Planning and Development.ARyan/DJaeger
Reference: SDC2026/01009
Phone: 02 4974 2768

9 June 2026

MIXED USE DEVELOPMENT - (SSD-89869959) – 10 DANGAR STREET WICKHAM

01 TYPICAL SECTION - THROUGH SITE LINK  
1:100

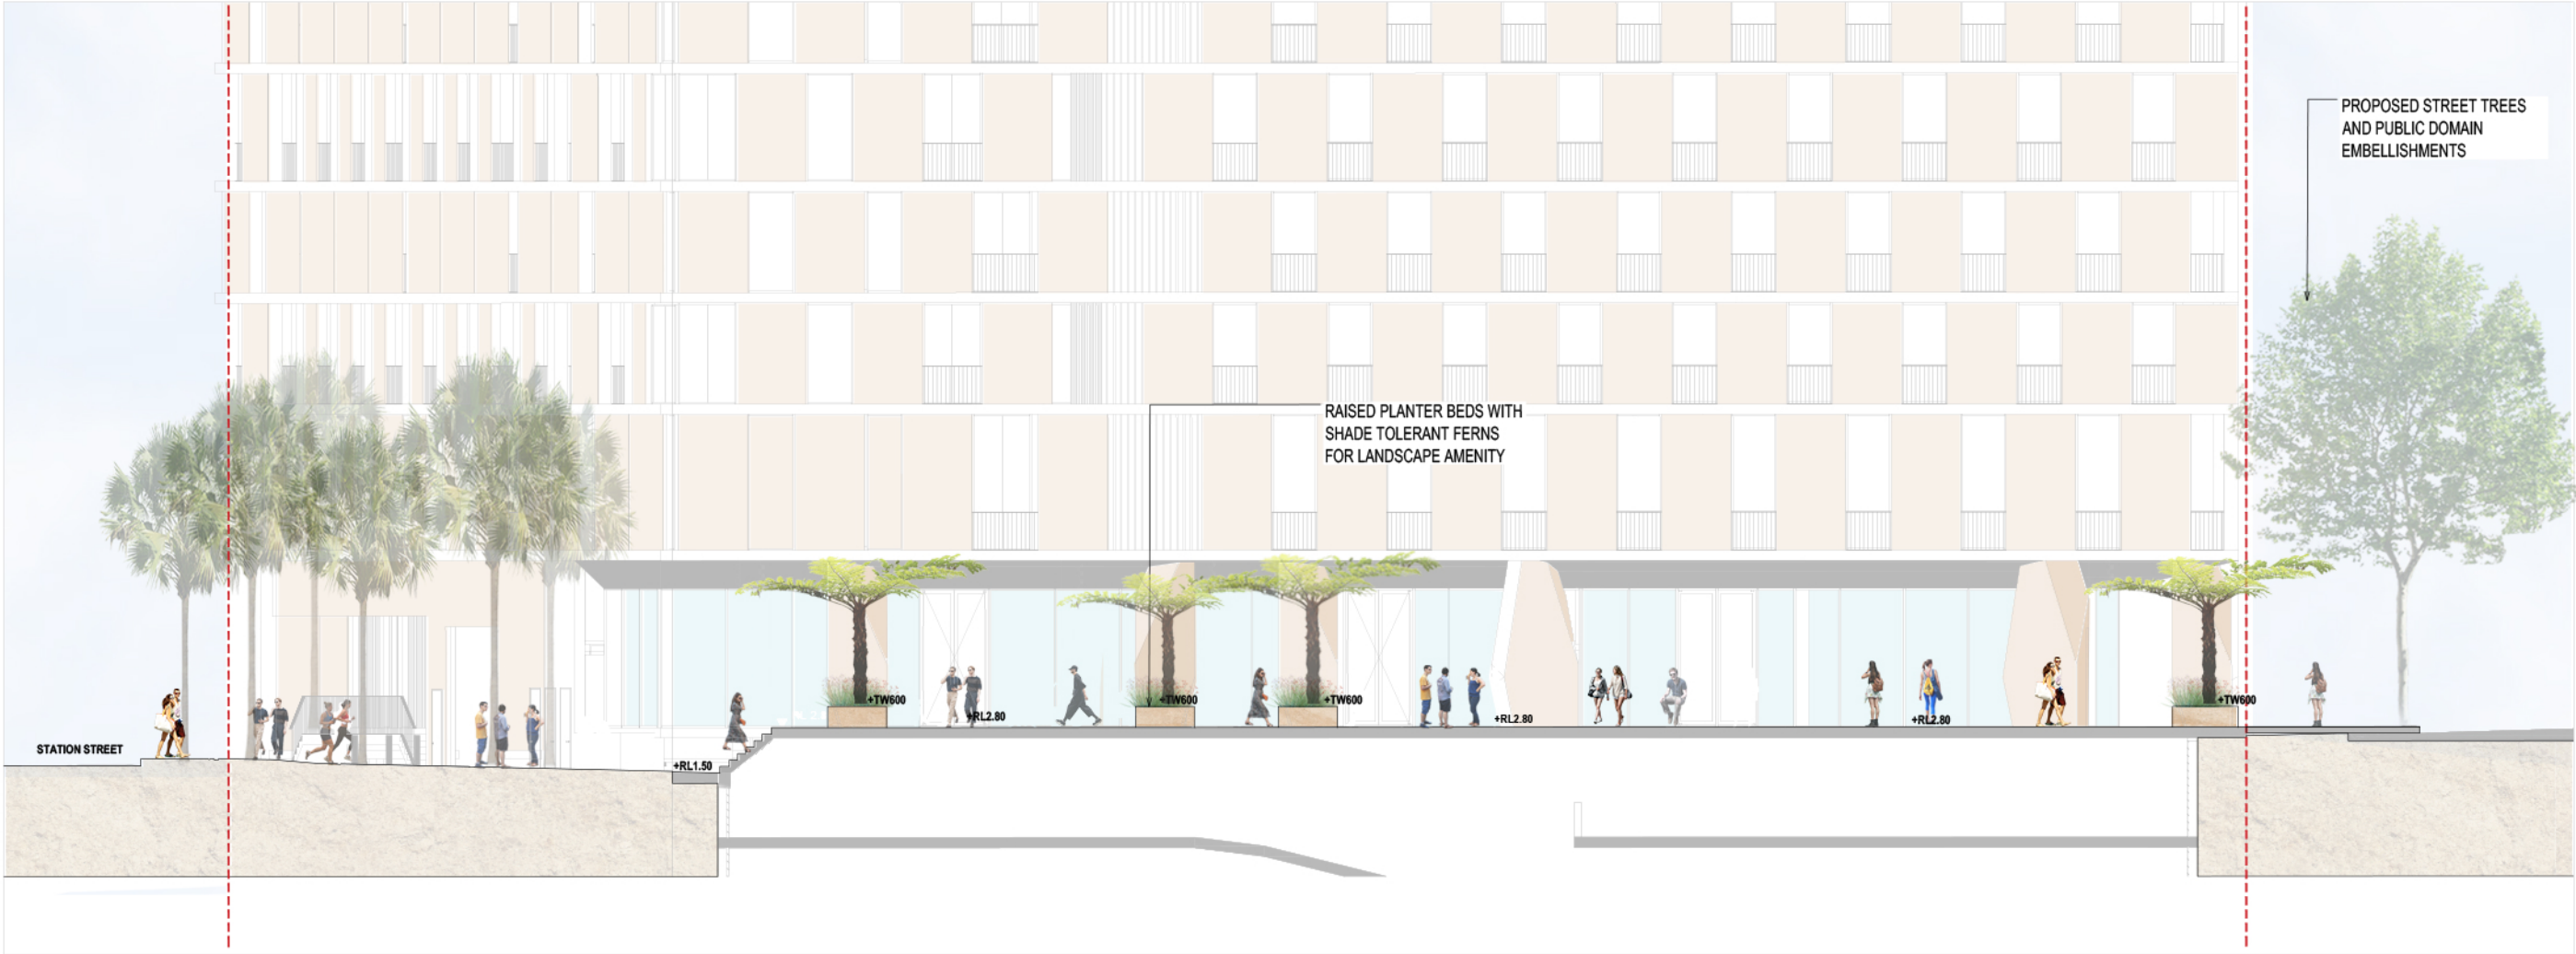
The design introduces a 'gully' between the proposal and the access to the Newcastle Interchange, which undermines connectivity. The public domain should support simple, direct, and accessible movement for pedestrians, cyclists, and people with accessibility needs. Instead, the proposal relies on a complex arrangement of ramps and stairs resulting in both poor connection and wayfinding.

There is also concern that the landscaping to the south will be largely overshadowed and unlikely to succeed, leading to substandard public domain outcomes. The submitted documentation is inconsistent, indicating that no work is proposed outside the site, and that works will occur beyond it.
